Blackpool Council - Development Management

Pre-application advice report

Reference: 20/0176

Proposal: Demolition of existing building and erection of six storey building to form a Cafe to ground floor and permanent flats to the upper floors.

DRAWING TITLE  
**PROPOSED FLOORPLANS  
FIRST & SECOND**

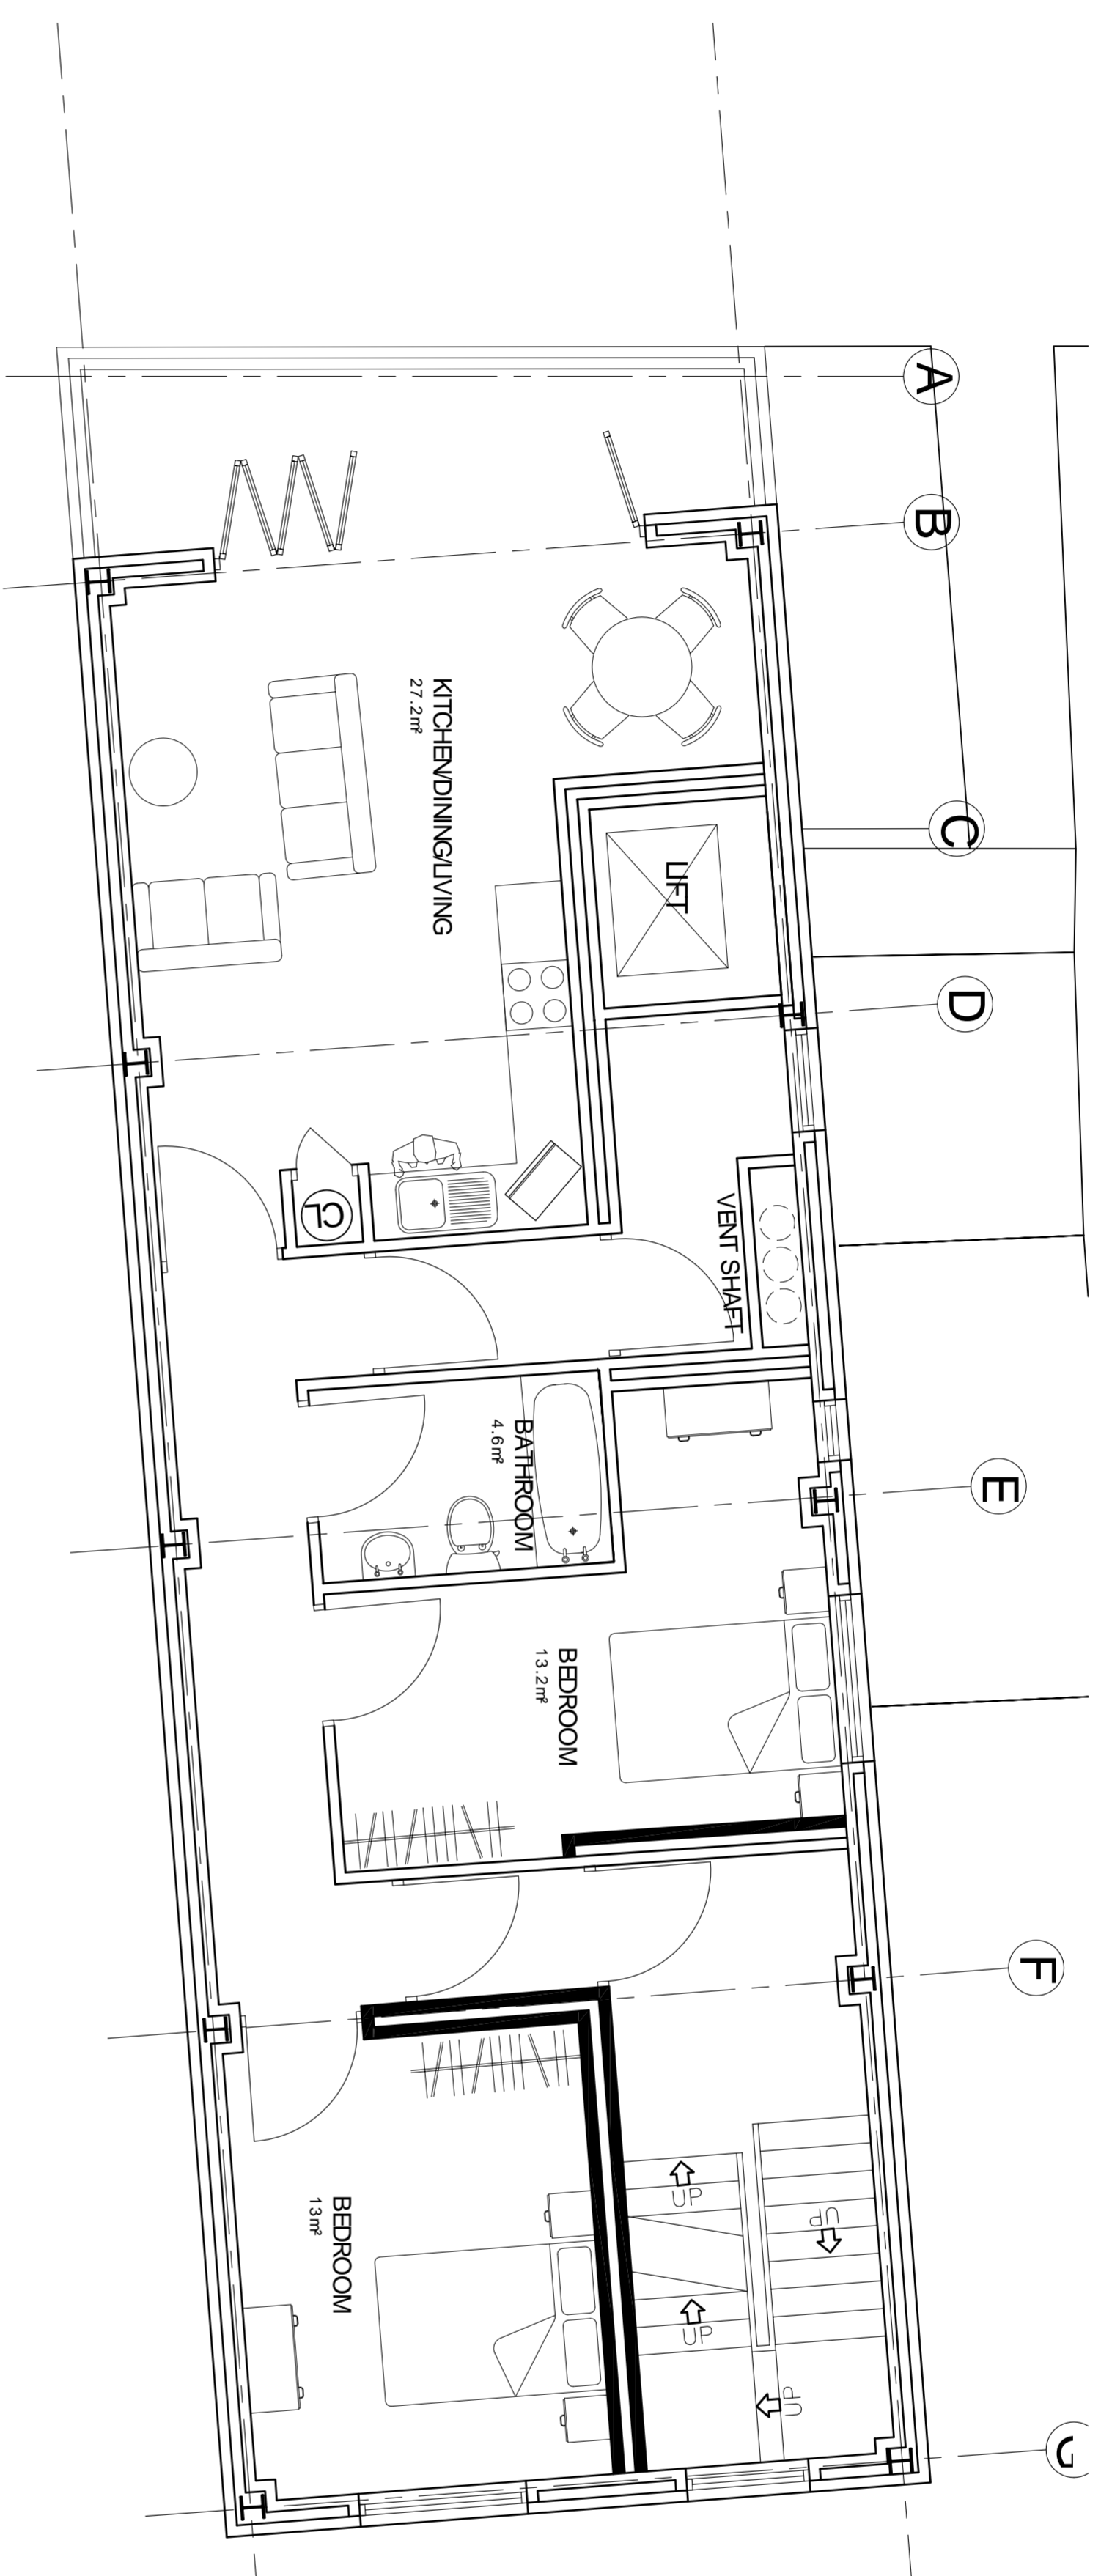
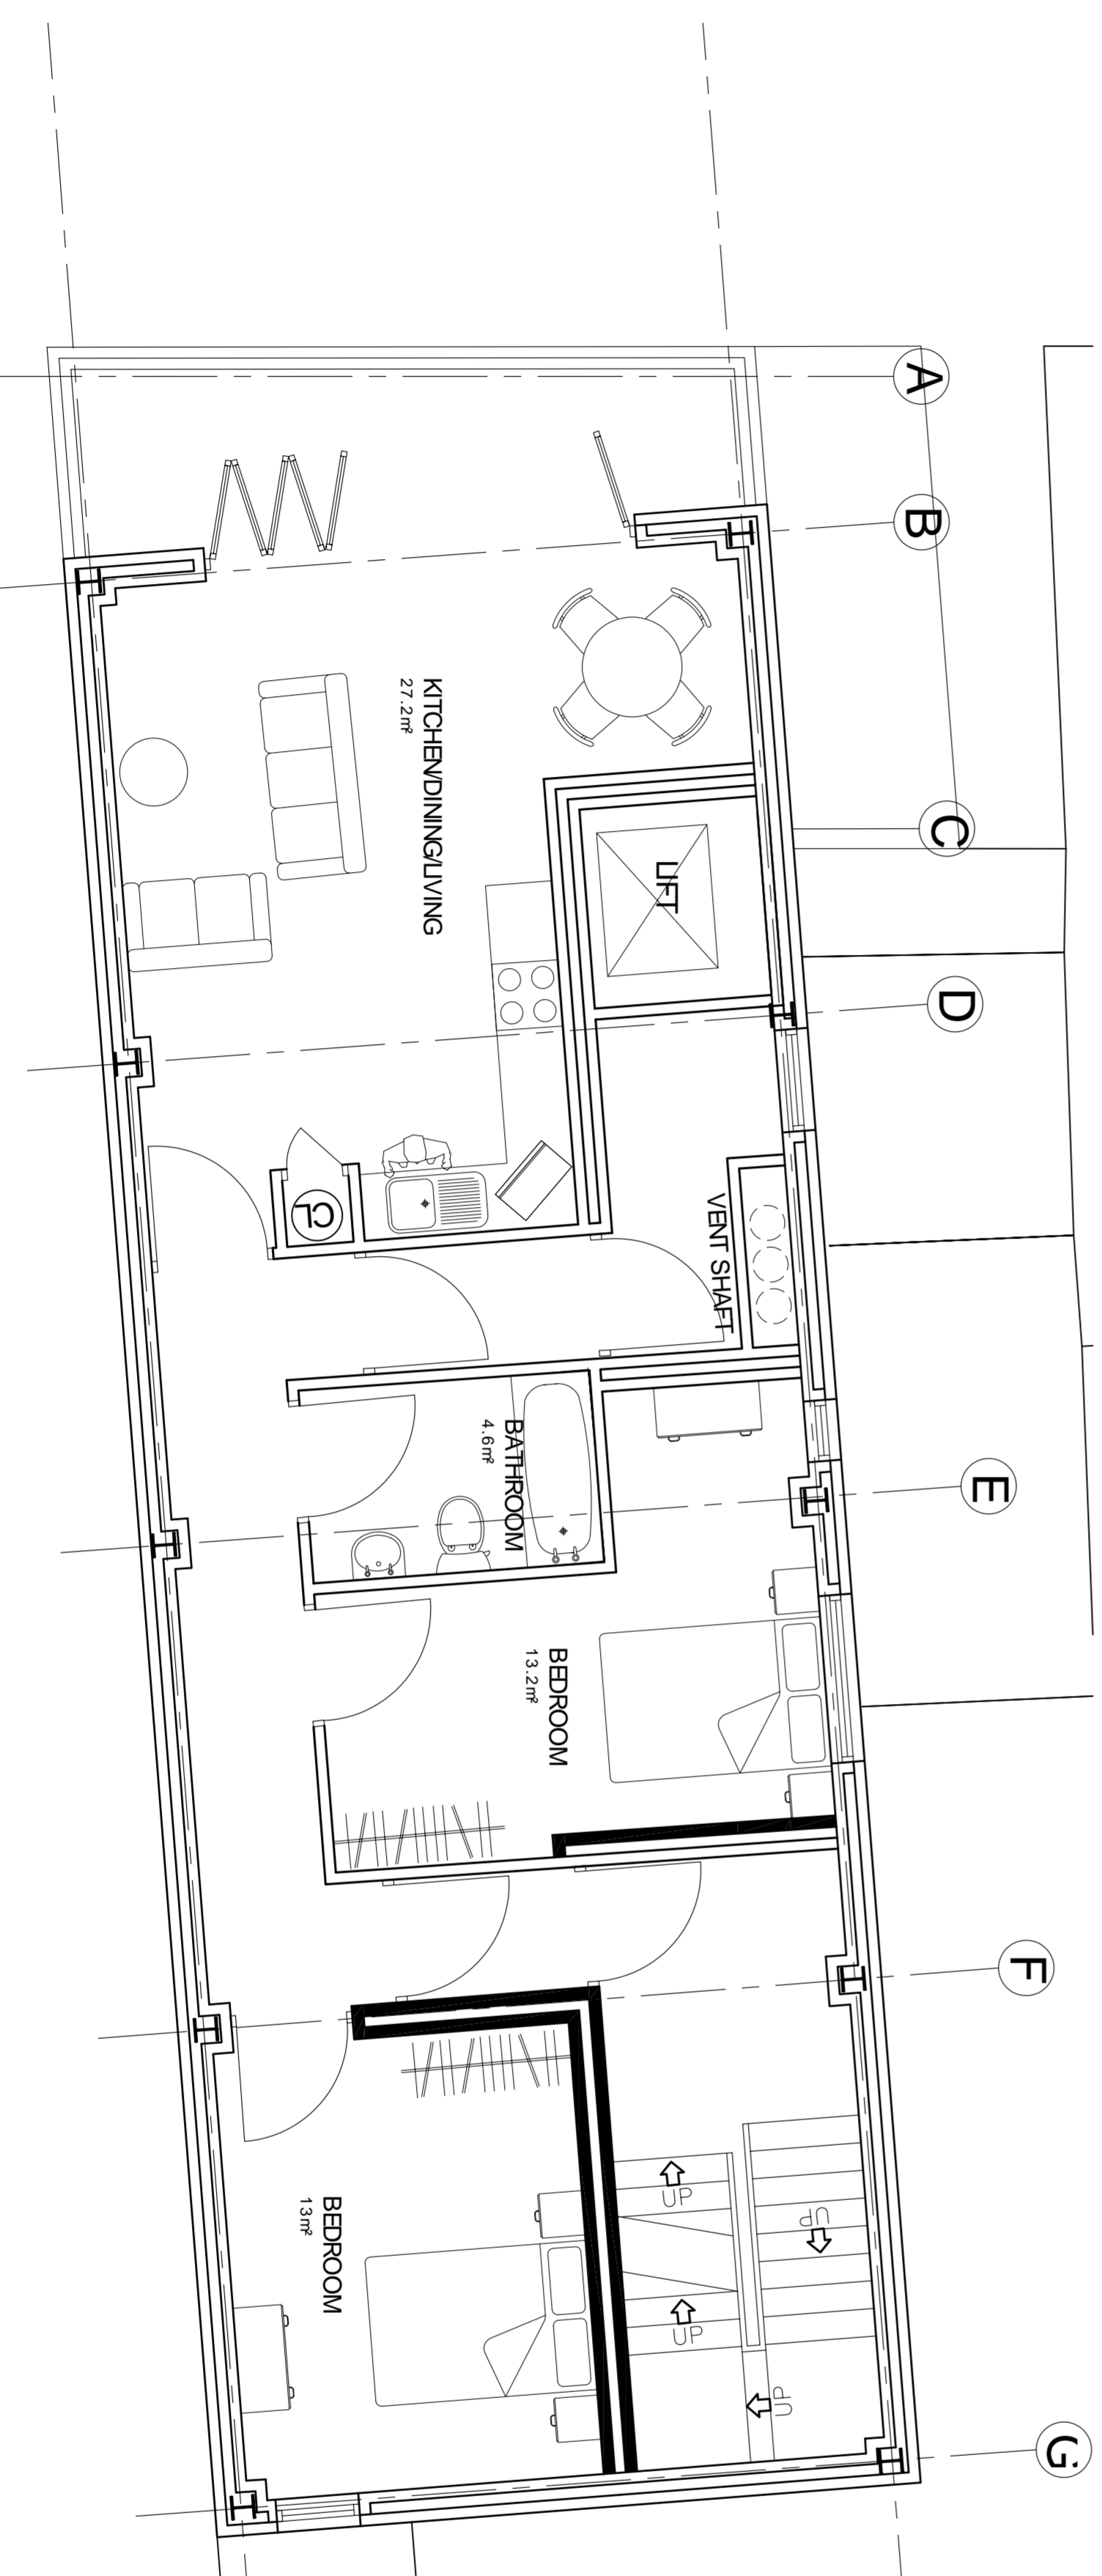
- 5.2.3 There does not appear to be any refuse storage for the upper floor flats; nor access to a communal refuse storage facility at ground floor level.
